Shear Design
2 Saffron Close
Shoreham By Sea
BN43 6JF

Our Ref: R/183/19/CLP
Your Ref:

Application for Lawful Development Certificate for a Proposed Use or Development

Development Lawful development certificate for a proposed rear extension to replace existing conservatory.
Location 13 Albert Road Rustington

Block Plan
Scale: 1:500

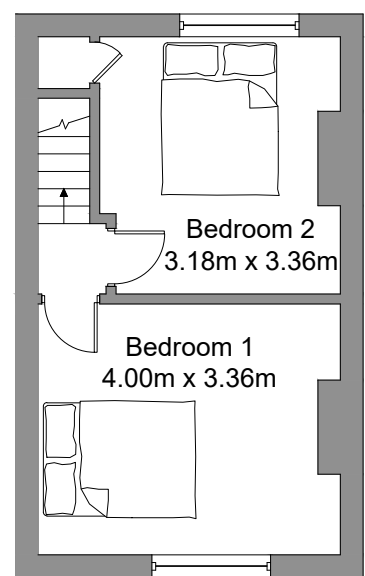
Please amend the Block Plan to show the measurements to boundaries.
